# SUBSURFACE WASTEWATER DISPOSAL SYSTEM APPLICATION

Subject: Approval, Replacement System Variance Request, Thompson Estate Property, Island Avenue, Cliff Island, Portland

We have completed our review of an HHE-200 Form dated 09/30/06 by John M. Toothaker, S.E. for your property at Cliff Island. You are proposing to replace an overboard discharge, with a 1,000 gallon septic tank, one OxyPro 1000 treatment unit, and three rows of four Eljen In-Drains. The disposal area has been reduced in size by 50 percent pursuant to Table 603.1 of the Subsurface Wastewater Disposal Rules, relating to treated wastewater. The test pit log on page 2 has no slope information in it. Notes #2 and #6 were not completed, on page 4 of the application. The following variances to the Rules, CMR 241 are requested:

DISPOSAL FIELD CROSS SECTION

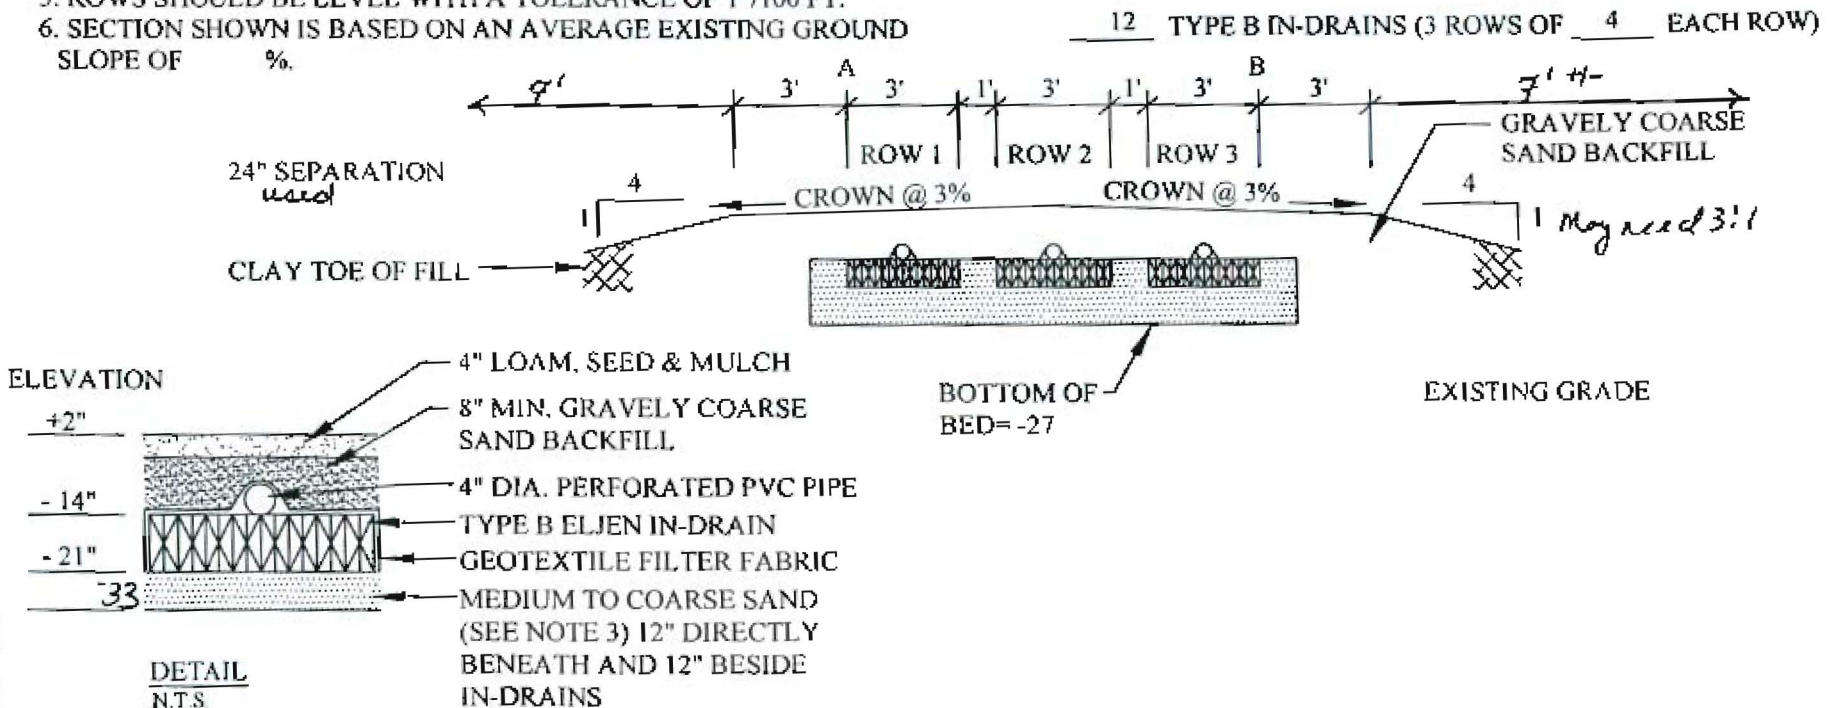
1. Prior to issuance of a permit to install the system, the Site Evaluator shall provide the owner and the Local Plumbing Inspector with a revised page 2 and page 4 of the HHE-200 Form, containing the data noted above.

1. FILL REQUIREMENTS VARY GREATLY BECAUSE OF BED LOCATION. CONTRACTOR SHALL FIELD CHECK ALL SLOPES BEFORE DETERMINING ACTUAL FILL REQUIREMENTS.
2. NOTES ON PAGE 4A OF 4 ARE HEREBY MADE PART OF THIS HHE-200 FORM. *Revised Nov 30-2006*

5. ROWS SHOULD BE LEVEL WITH A TOLERANCE OF 1"/100 FT.
6. SECTION SHOWN IS BASED ON AN AVERAGE EXISTING GROUND SLOPE OF 0%.
